From: Laura Gibbons
Sent: 27 July 2018 11:45
To: Planning.Responses
Subject: RE: Planning Consultation on BR/173/18/DOC

Engineers Comments Regarding Condition 3

BR/173/18/DOC

10-12 Land At Devonshire Road Bognor Regis PO21 2SX

TITLE:
PROPOSED DRAINAGE STRATEGY

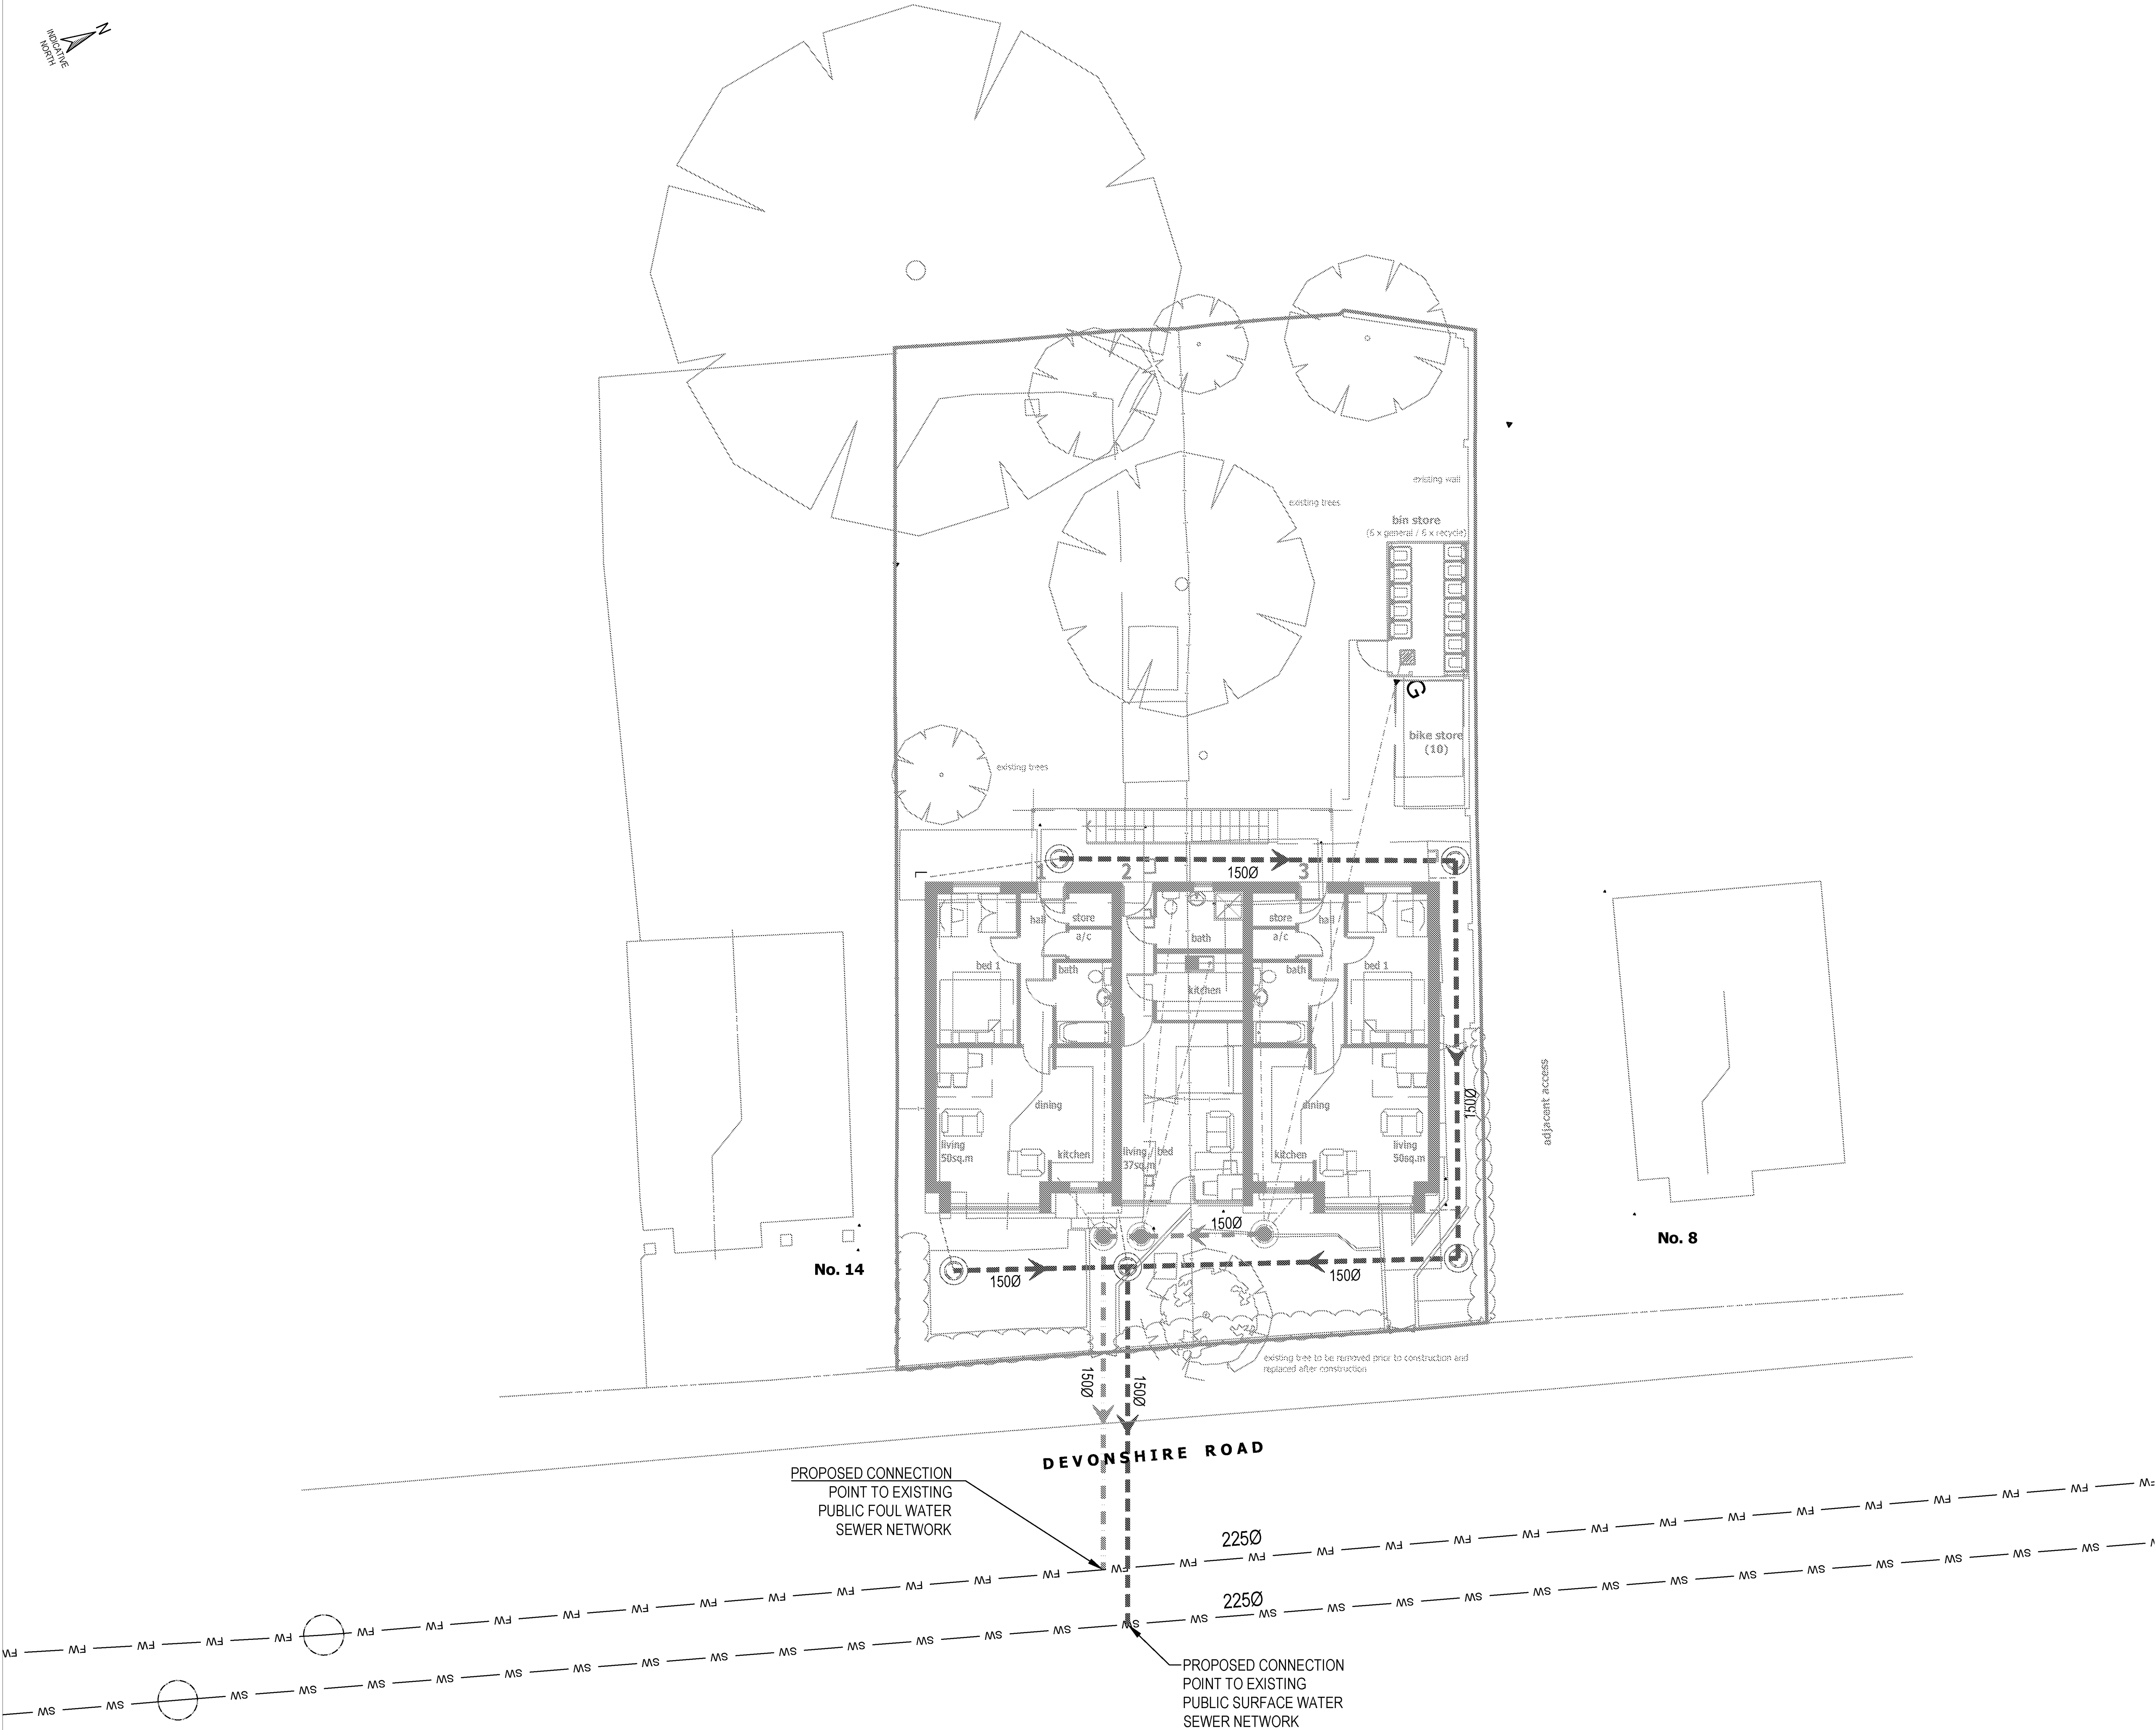
The proposal is to dispose of surface water into the surface water sewer un attenuated as a result of exceptionally high groundwater levels encountered on site. In order for us to discharge this condition we require proof that southern water are happy with this proposal, i.e. S106 and capacity check.

All areas of paving should be permeable paving as these are not currently included within the drainage proposals and would otherwise increase runoff.

The drainage layout plan should be updated to show locations of catchpits, invert levels, cover levels and fall of pipes. Please also provide construction detail drawings of manholes, pipe protection details and catchpits.
